From: Martyn White
Sent: 29 August 2019 17:03
To: Planning.Responses <Planning.Responses@arun.gov.uk>
Subject: FG/76/19/OUT

FG/76/19/OUT

Application for outline planning permission for the erection of 1No. dwelling house in rear garden

DRAWING TITLE
Proposed Floor Plans
PLANNING ISSUE

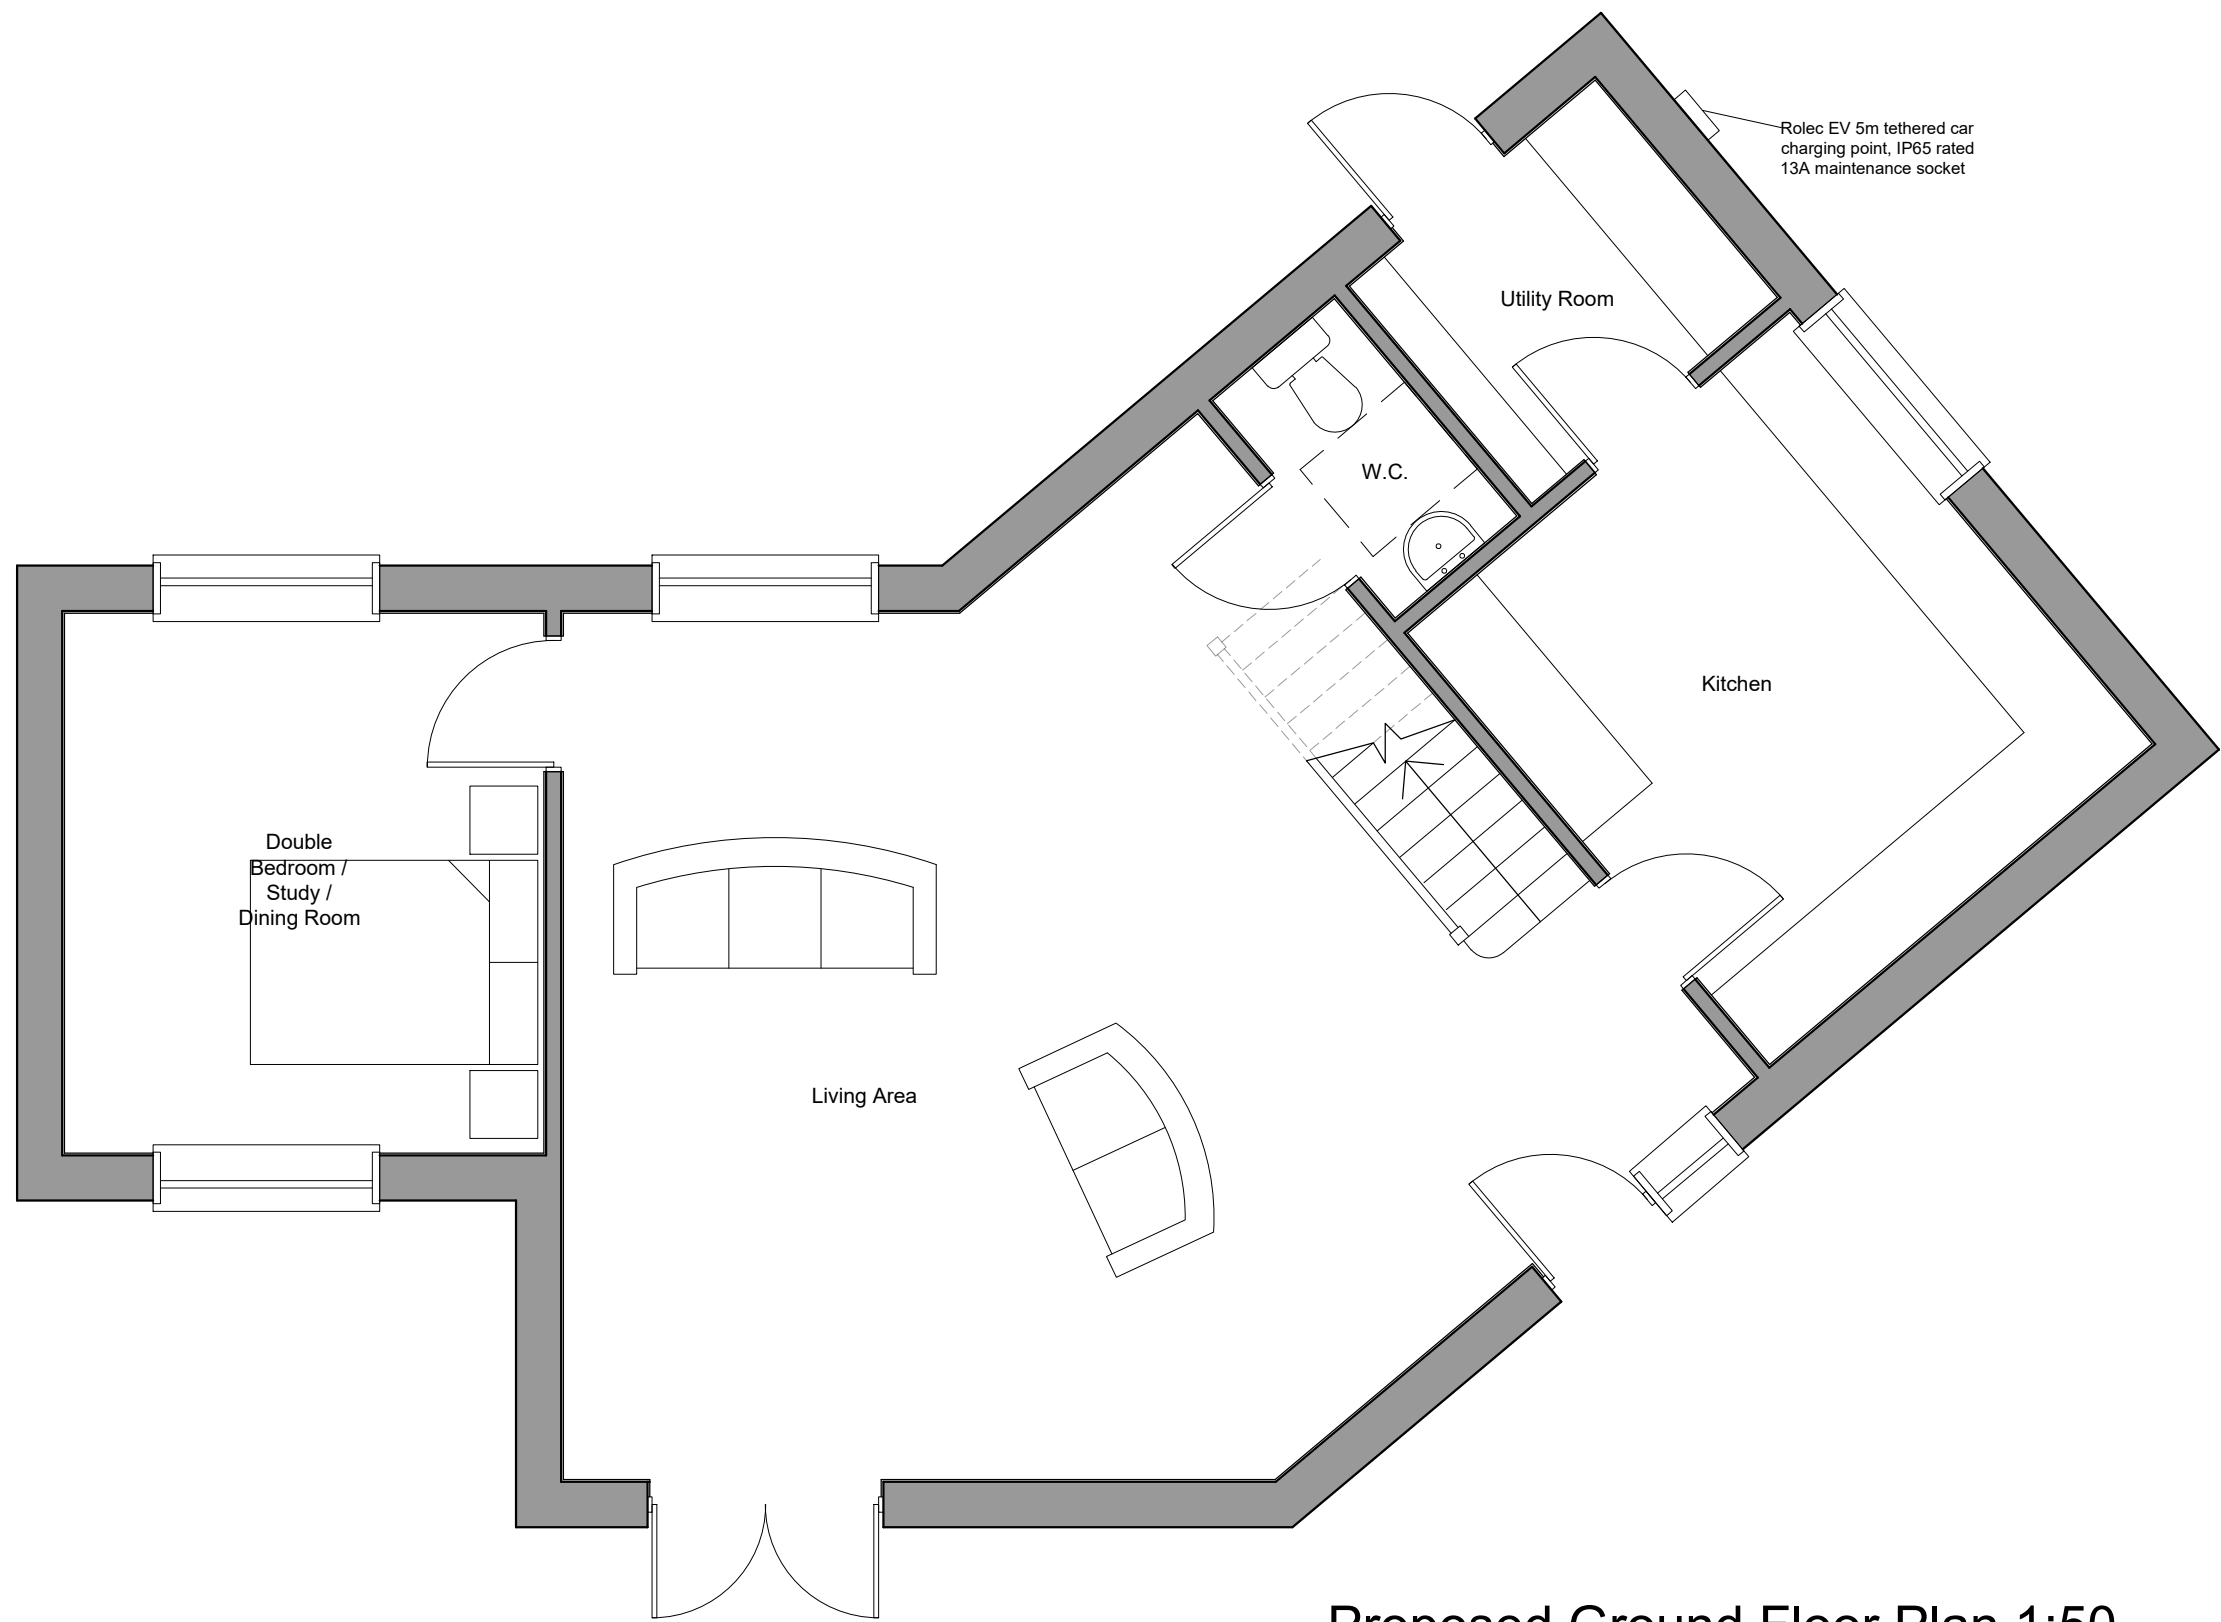
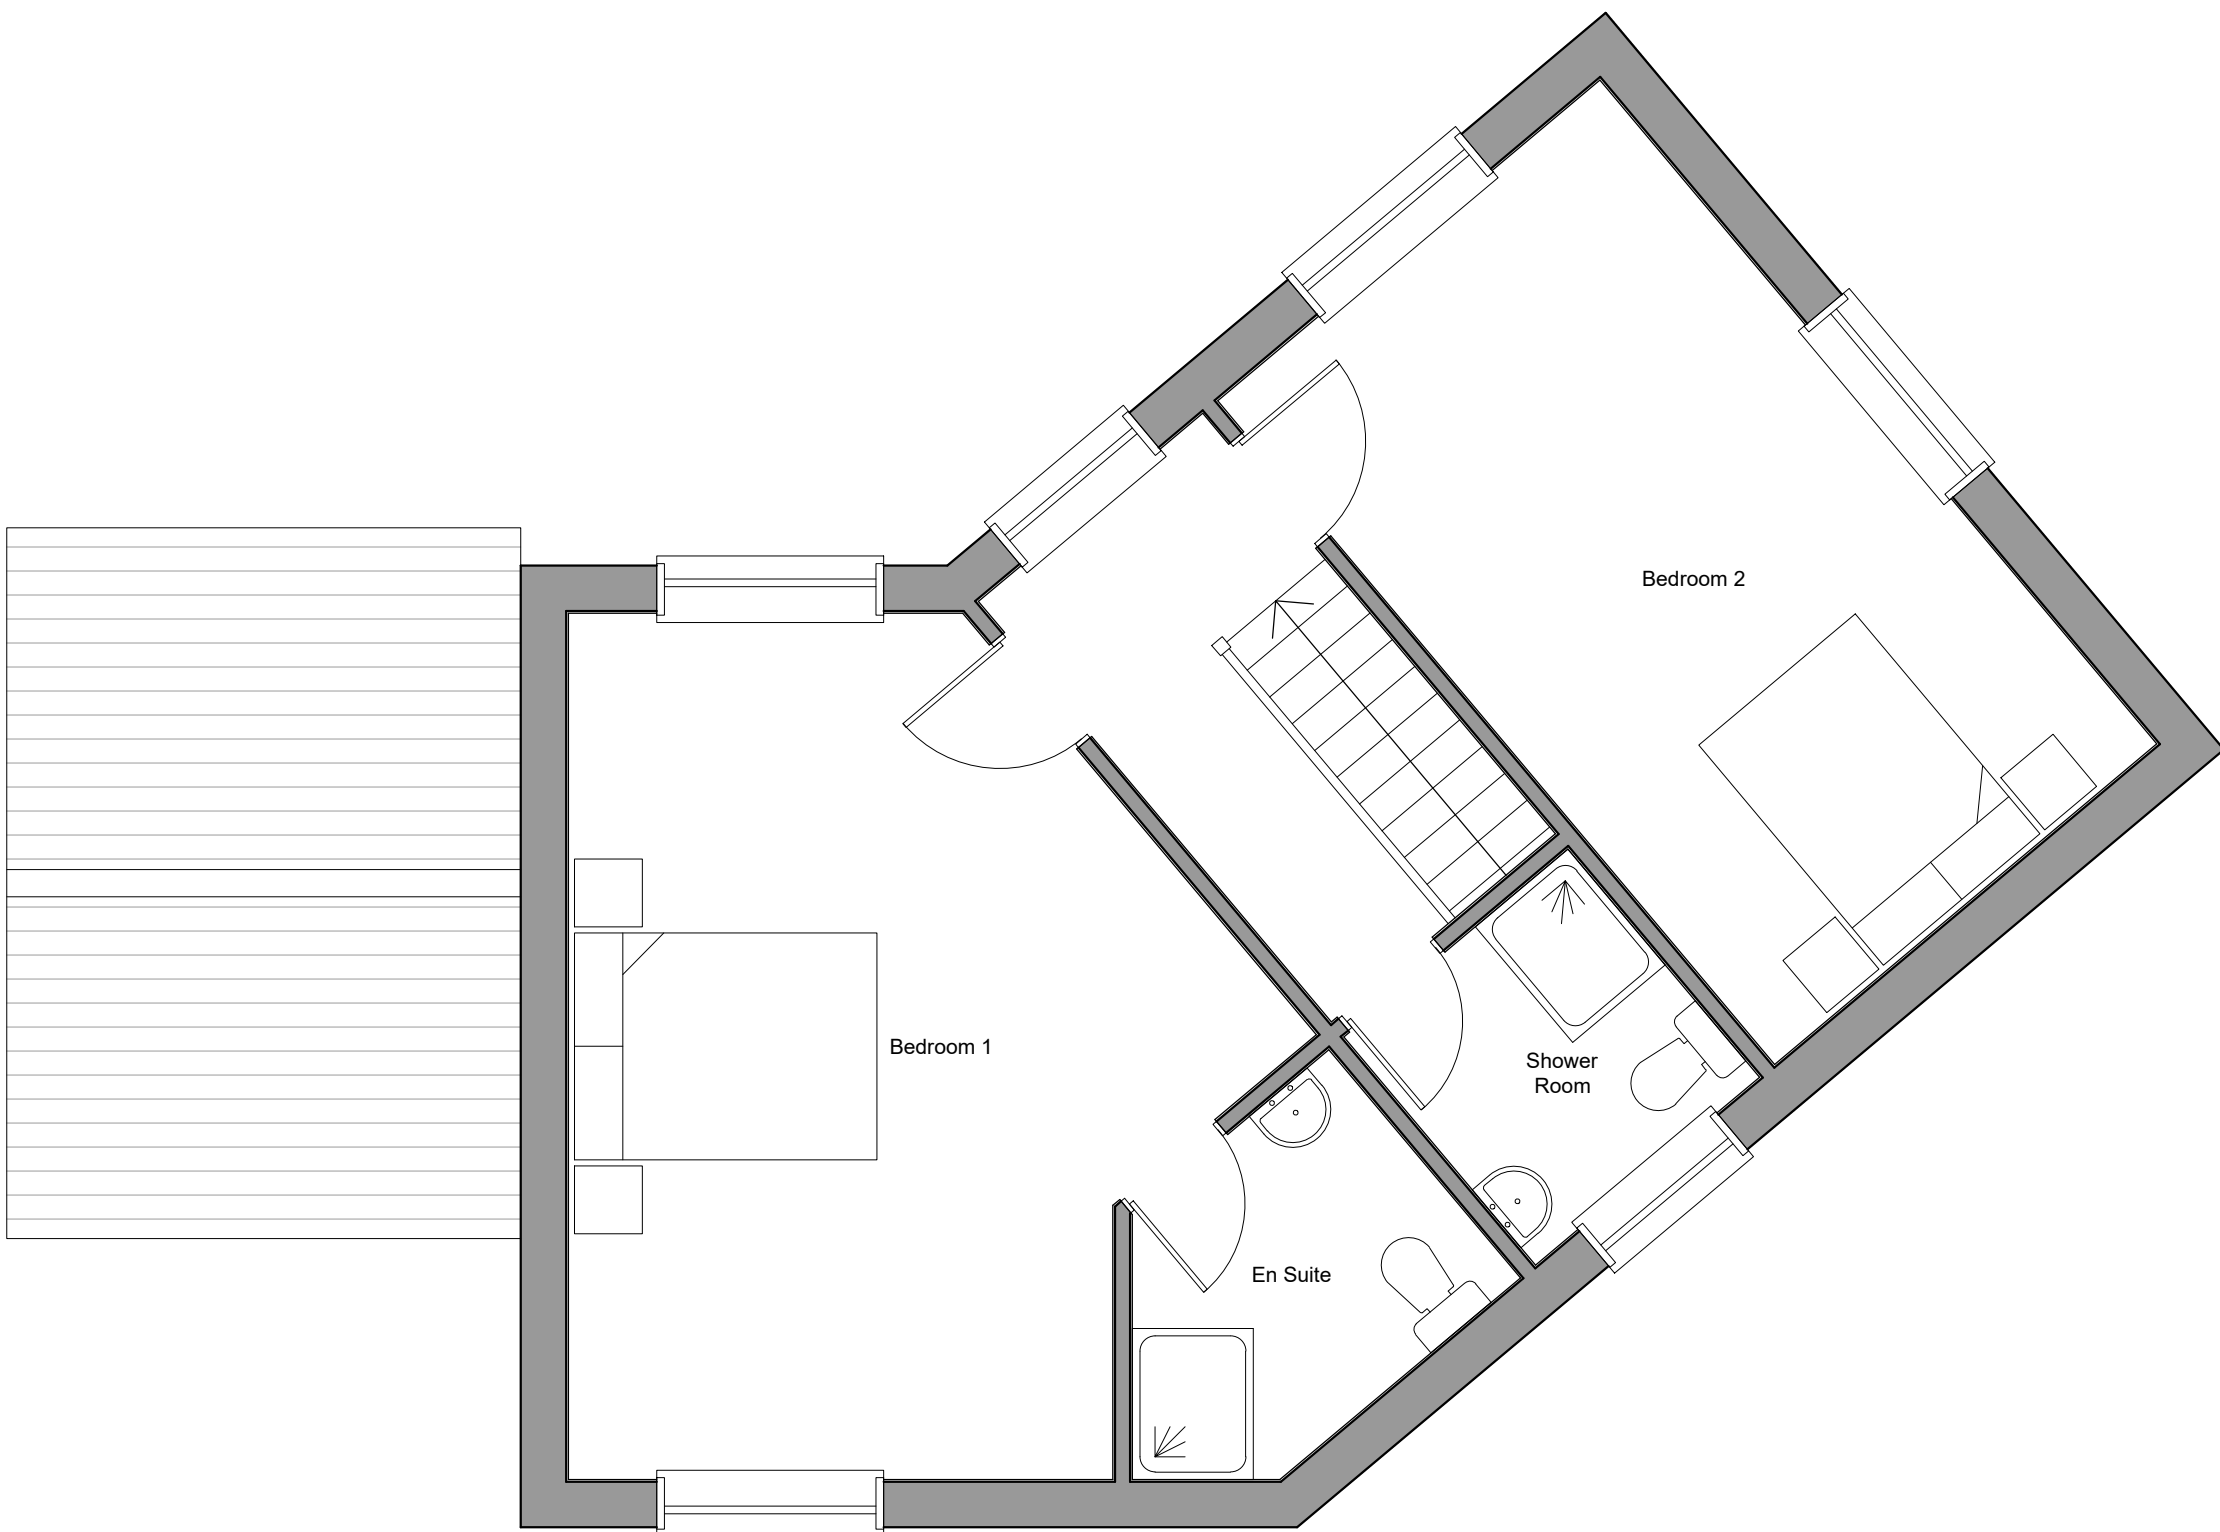
The proposal will introduce an additional property in the grounds of the host dwelling. Whilst no information is provided with regards to the elevational treatment of the building, floor plans have been provided, along with a block plan. My comments are therefore provided on this level of information.

The proposed development is set some distance from the host dwelling and would be located closer to a neighbouring property. However, the concept of splitting the existing residential plot, along with the introduction of a new boundary could potentially impact upon the setting of the existing residential unit. It would also result in the erosion of the spacious character of this part of the conservation area.

The information provided so far also indicates that the proposed dwelling would be of a more standard design, and not truly reflective of the more traditional ones located within the conservation area. At present, the proposal is considered to be problematical.
